**Consultation Response from KC,
Highways Development Management****2026/91690 Land adj, 7, Tommy Lane, Linthwaite, Huddersfield, HD7 5SQ****Demolition of existing stable block and erection of detached dwelling with detached garage and associated works****Date Responded: 15 July 2026****Responding Officer: Sheila Henley****Responding Ref: K2-9/19****Recommendation: No objection.**

Plan ref: 2507-0201-P03 - Site Layout Plan Section as Proposed; Fire Appliance Tracking; 507-0202-P02 - Proposed Floor Plans Elevations.

PROPOSED FLOOR PLANS & ELEVATIONS

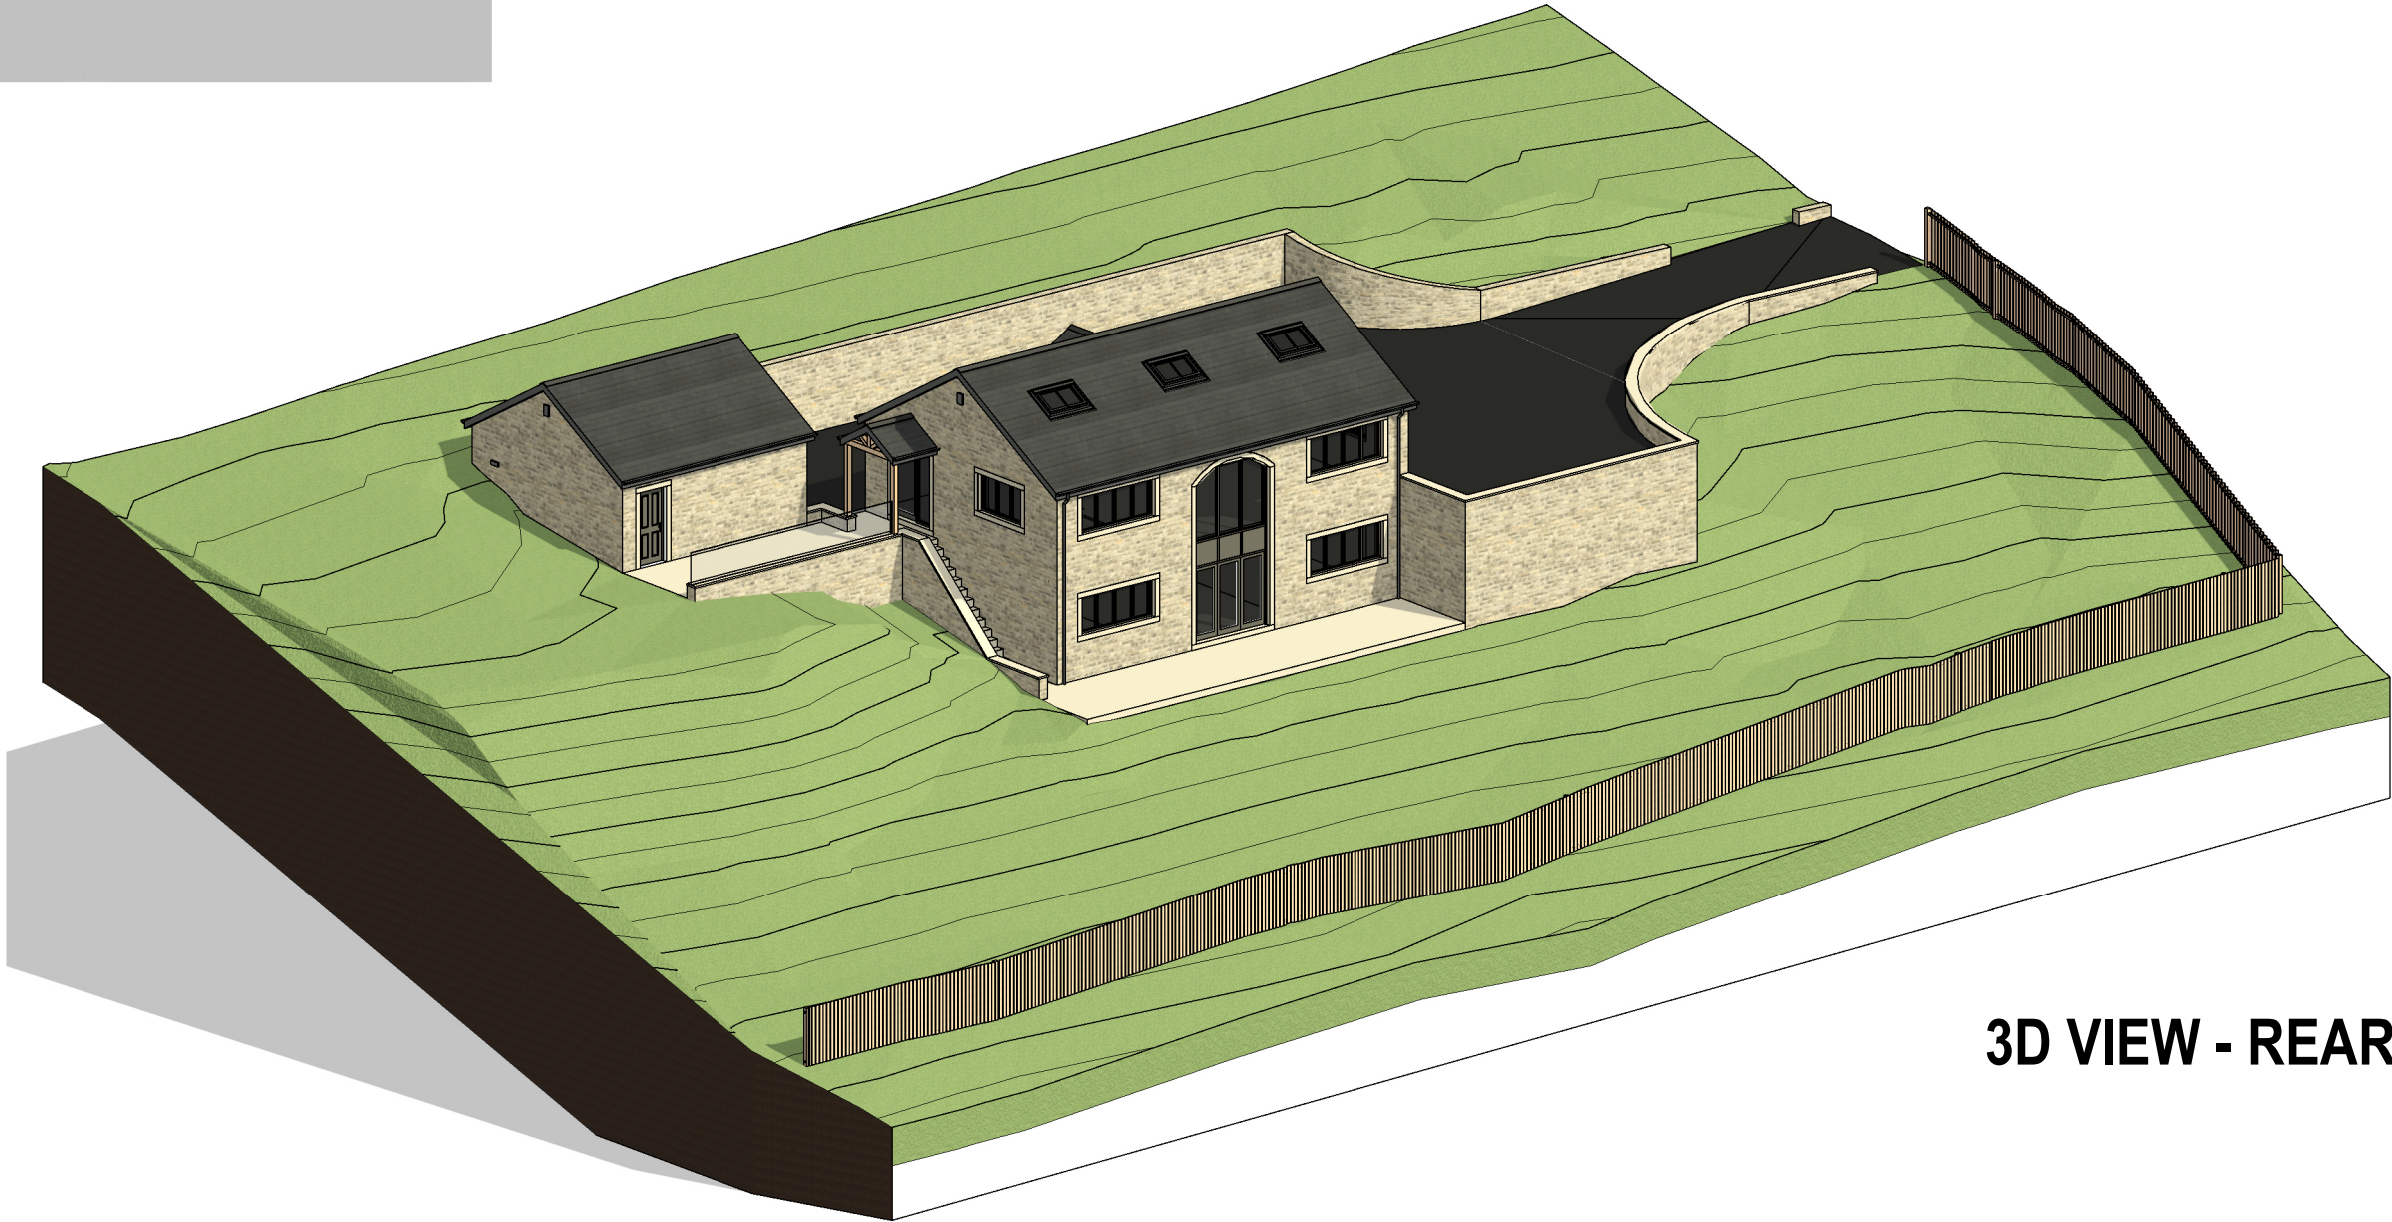
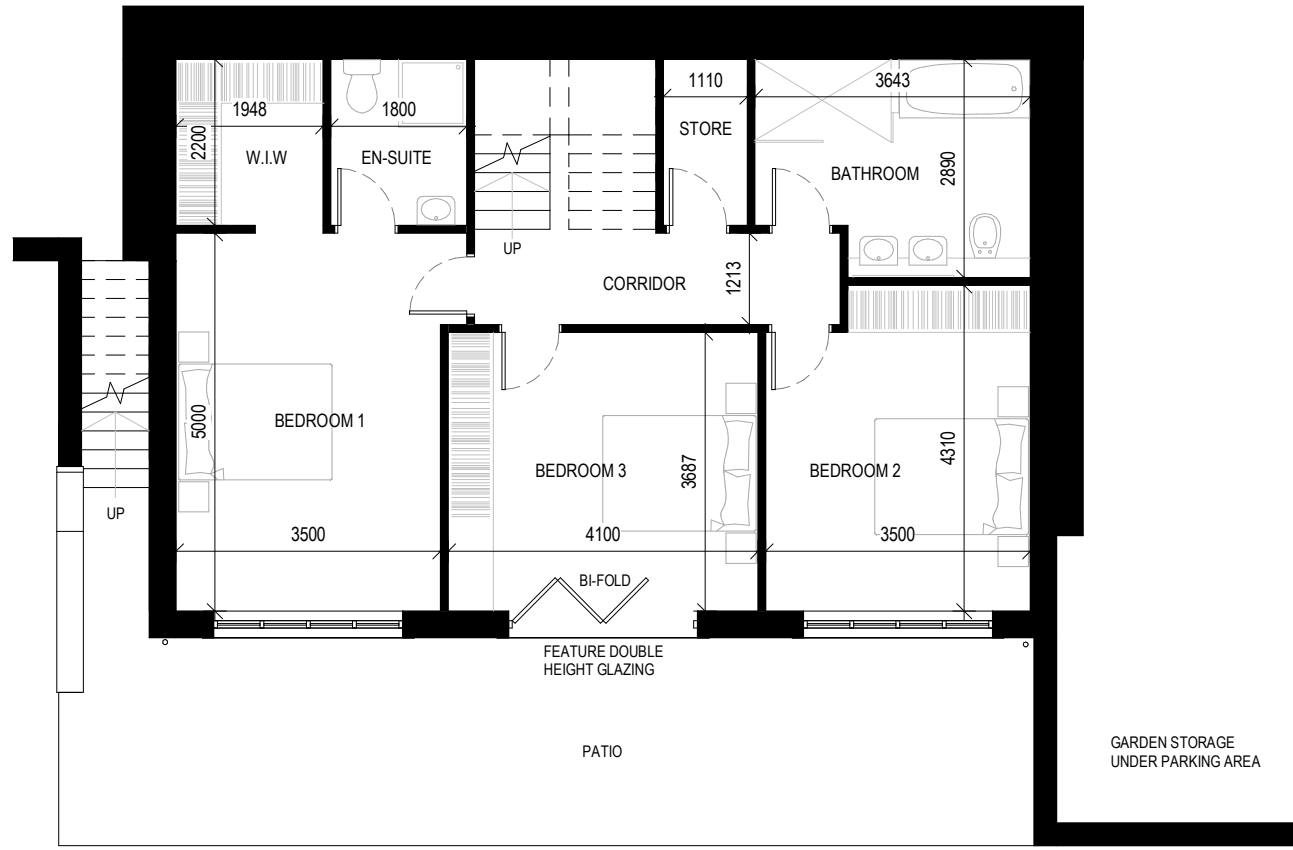
Within the plot, the internal dimensions for the proposed double garage are expected to be suitable for it to count towards car parking and the storage of cycles and other items. Notwithstanding, it would be a slightly shorter than recommended at 5.7m rather than 6.0m but wider at 5.7m than the advised 5.0m.

SITE LAYOUT PLAN & SECTION AS PROPOSED

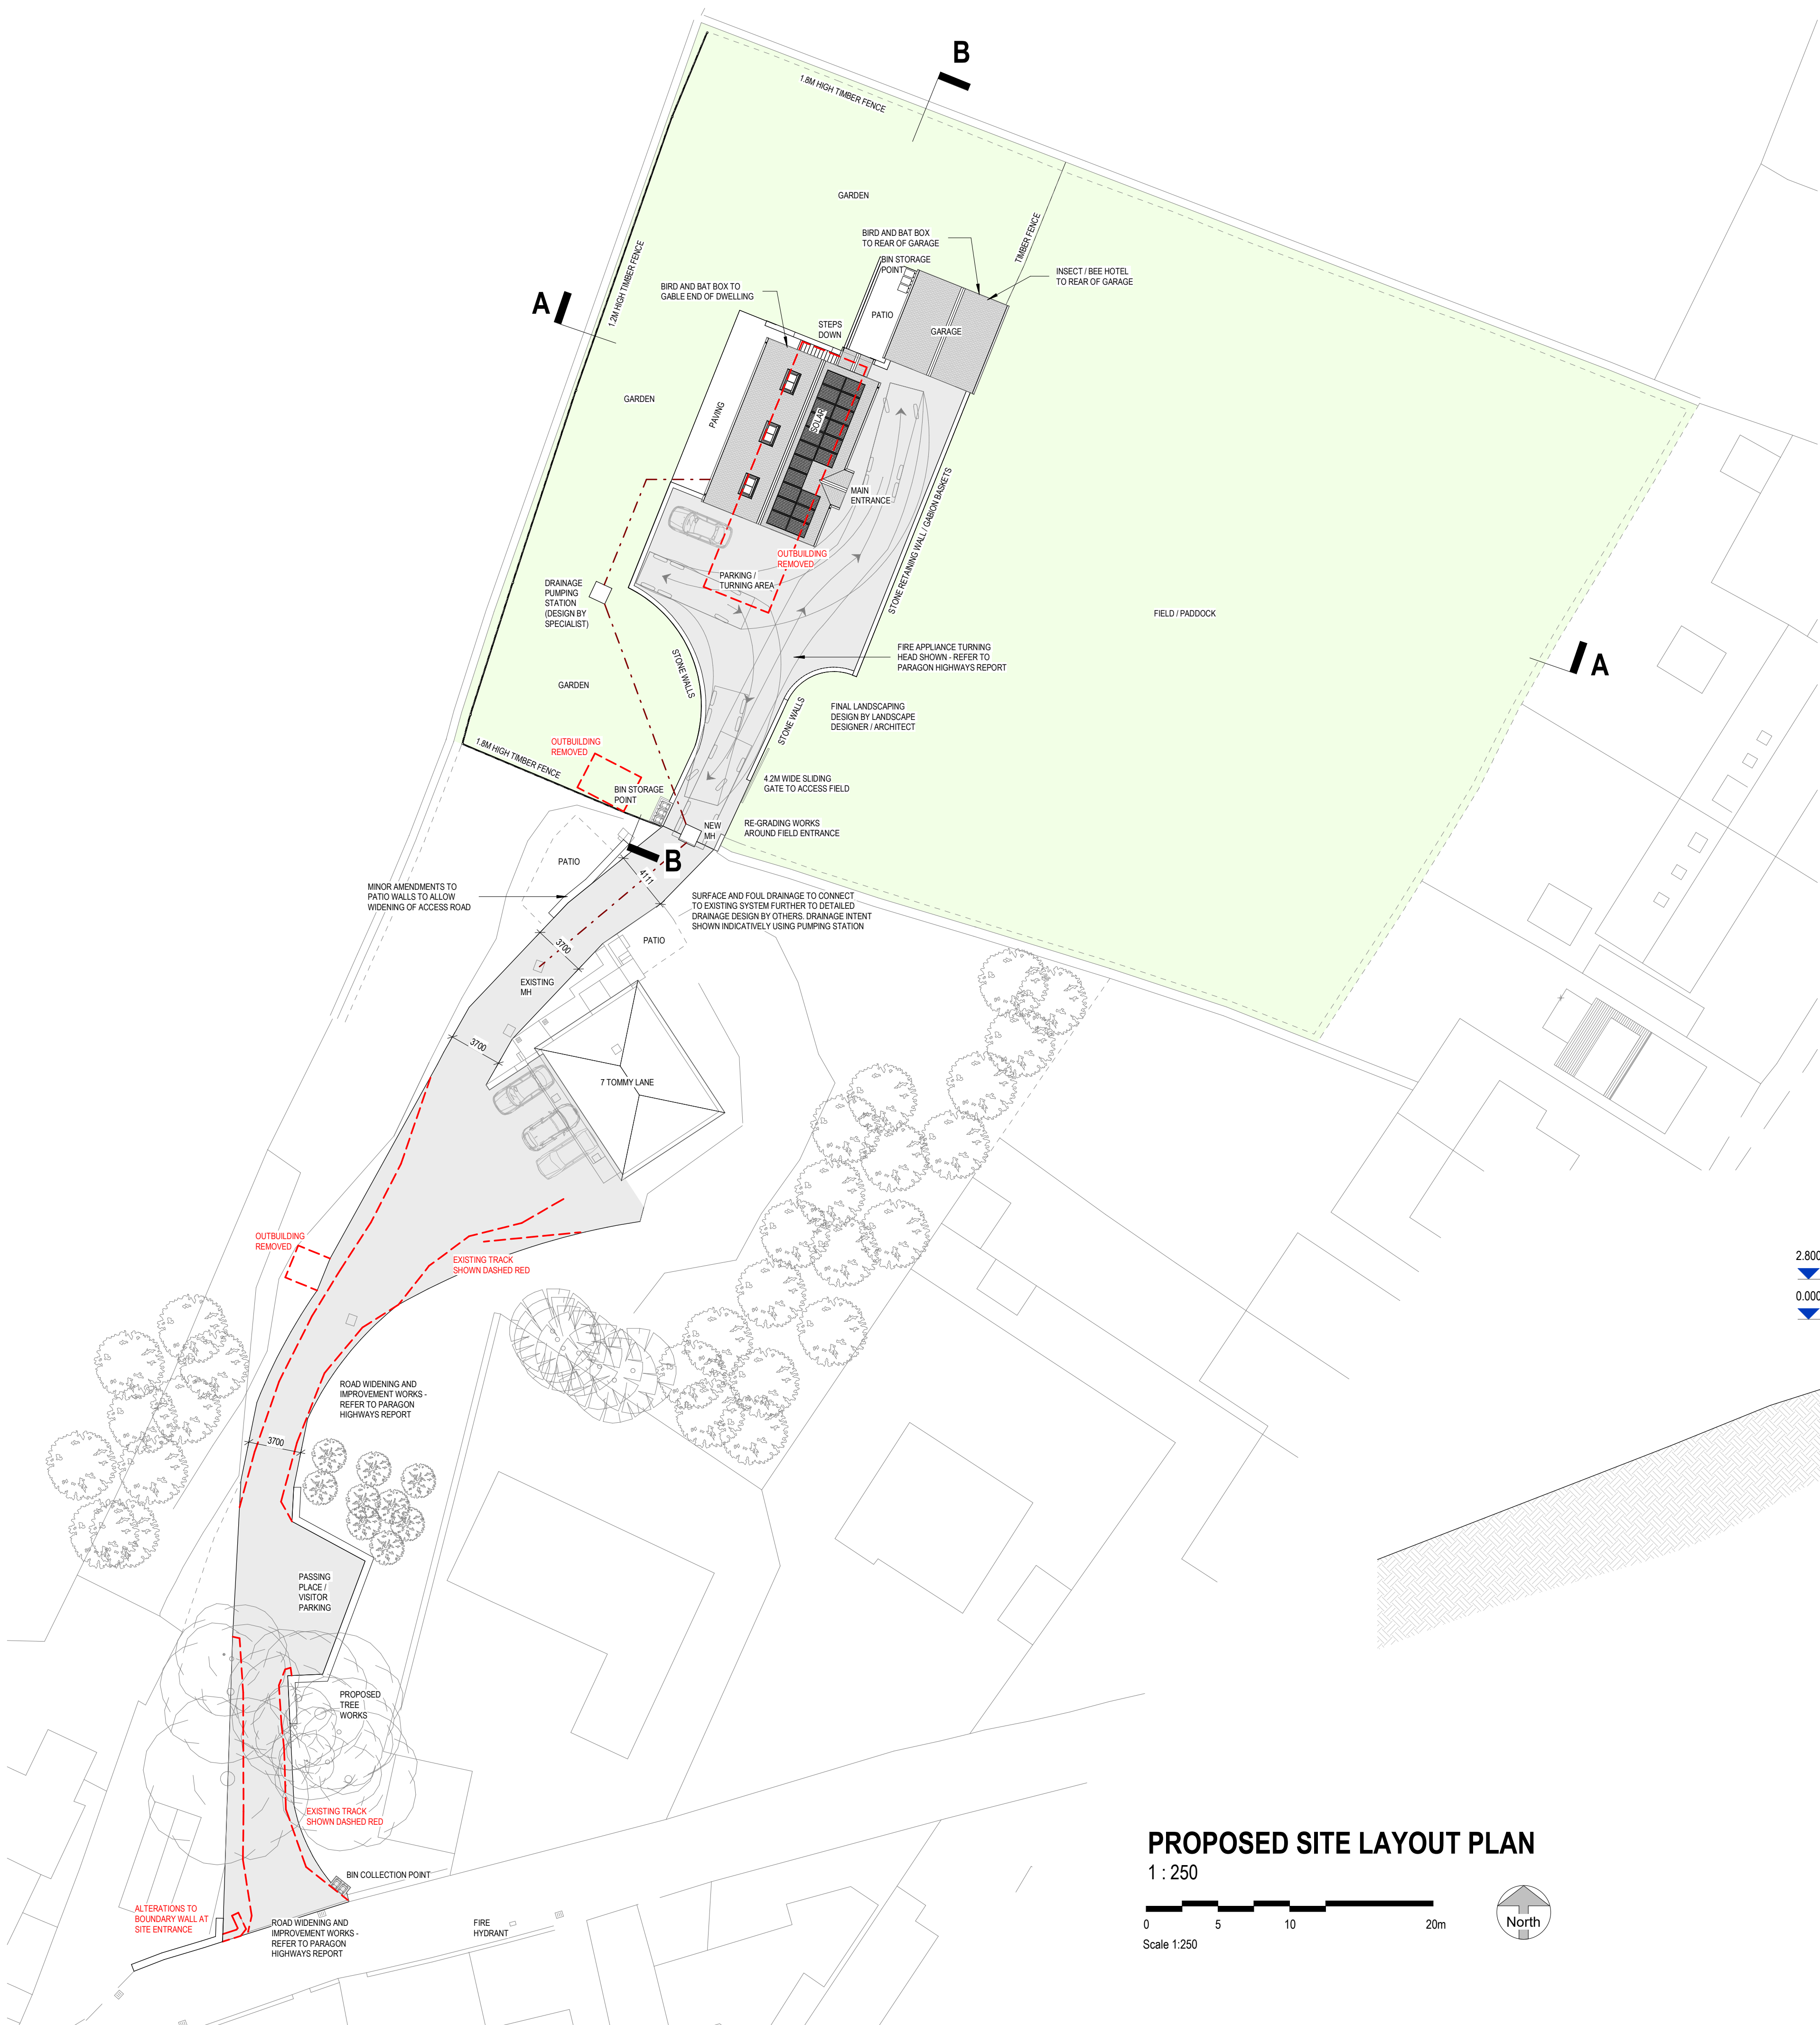
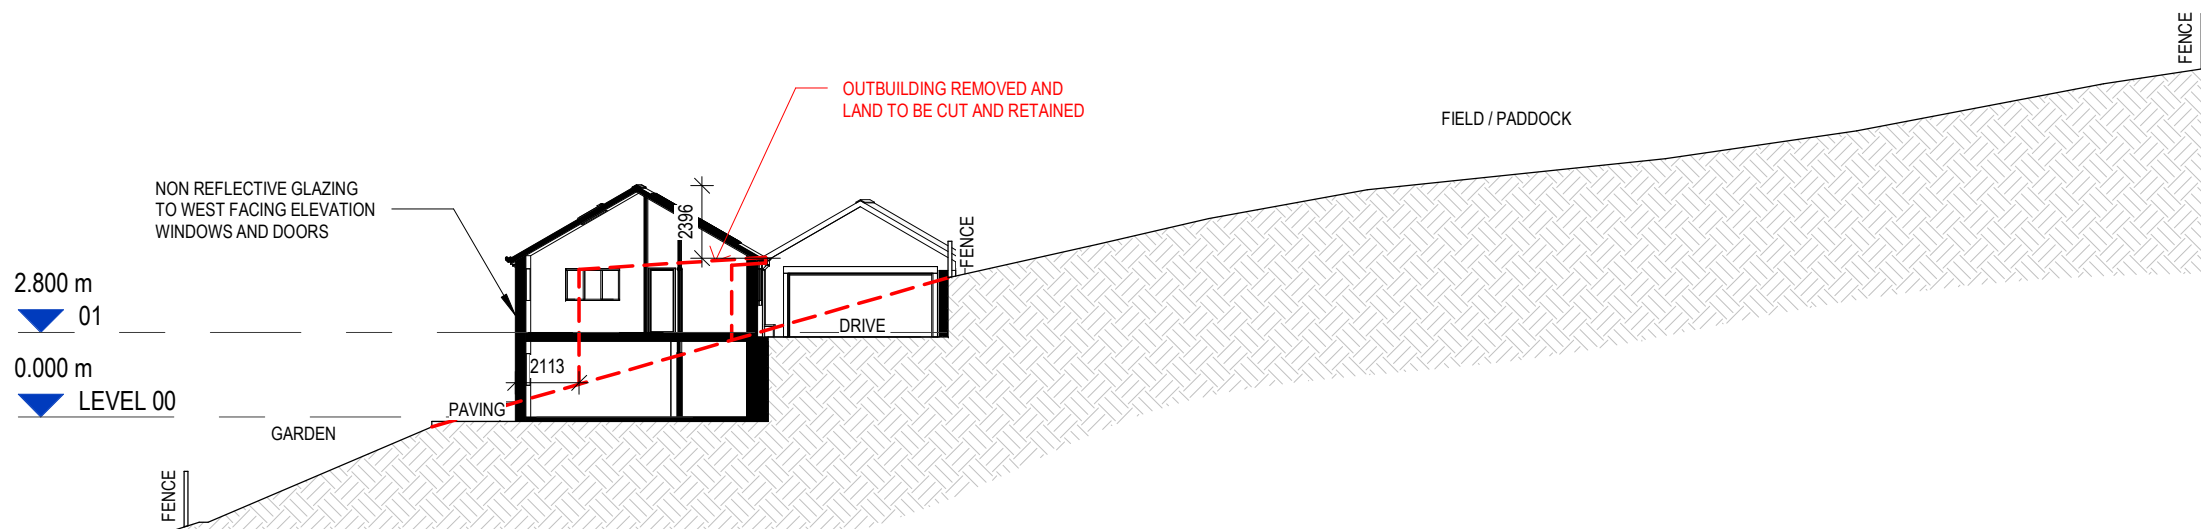
Modifications are to be made to the accesses points and track to reflect a private drive, additional residential use, and emergency vehicle provision by widening the existing access at Tommy Lane from 7.4m to 9.2m on altering the boundary wall. This would better cater for two-way movements and larger vehicle movements. and improve lines of sight.

The field access would be regraded, surfaced, and provided with an electric sliding gate.

The shared driveway serving 7 Tommy Lane is to be widened towards its garage, defined towards the current field and resurfaced in a permeable tarmacadam with a 3.7m minimum width. There is to be passing place / visitor parking bay c20m after the Tommy Lane access. These changes are suitable to allow access and passage for shared use, including for emergency vehicles.

The exterior parking and turning arrangements would be suitable, including for vans, as well as fire and rescue appliance access as demonstrated by the submitted swept-path analysis indicating reverse manoeuvres within the proposed turning head to show forward gear entry and exit.

The amount of car parking of three / four spaces would be above the advice in the Kirklees Highway Design Guide SPD of two spaces for three bedroomed units but would provide flexibility such as for turning and extra visitor parking to meet policy LP22. It is intended to provide a formal visitor space within the private drive to meet the suggested one space per four units.

There is to be space for bin storage and intended to be located by the proposed gate with a bin collection point formed close to the main access junction with Tommy Lane. The bin storage area and pull distances are long and care would need to be taken on usage.
